## Portland Water District

June 27, 2016

Re: 23 Ocean Avenue - Portland  
Ability to Serve with PWD Water

**UTILITY & STORMWATER MANAGEMENT PLAN**

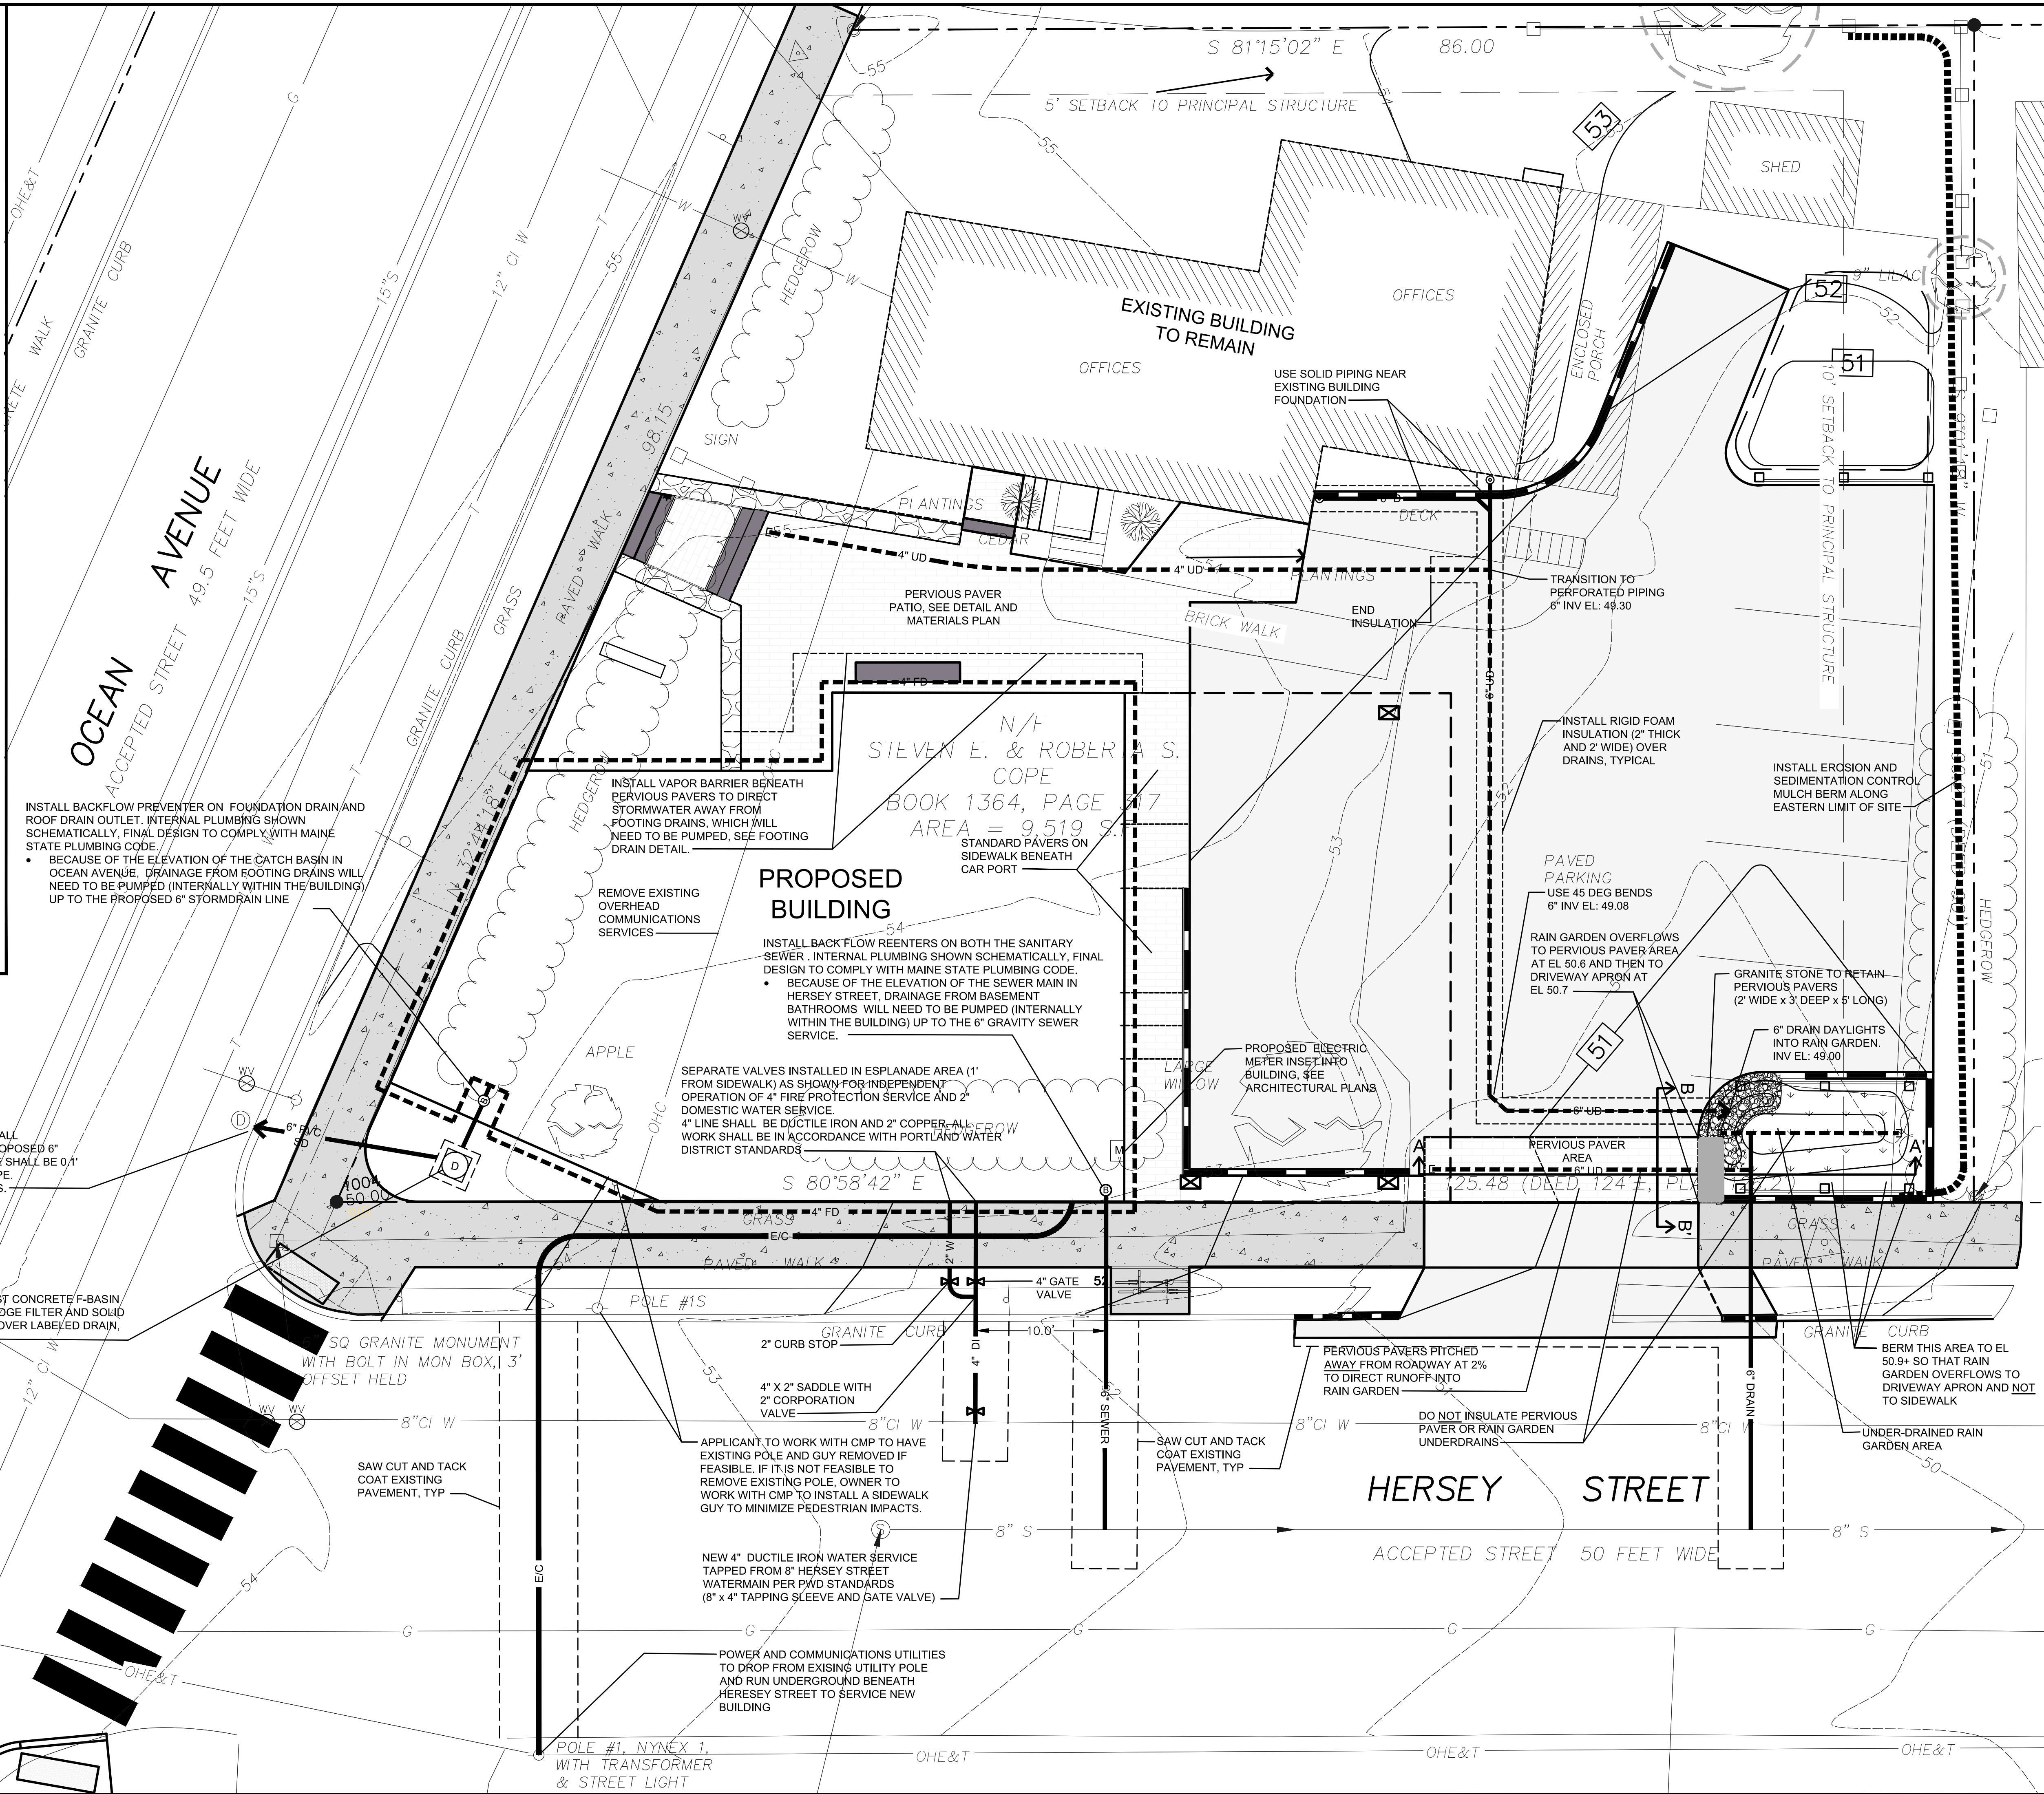
- A new 4-inch fire service and 2" domestic service may be installed to the new building from the water main in Hersey Street as shown on a plan entitled Utility Plan for 23 Ocean Avenue. We will need written confirmation from the sprinkler designer that the 2" domestic service tapped off the 4" service is acceptable.
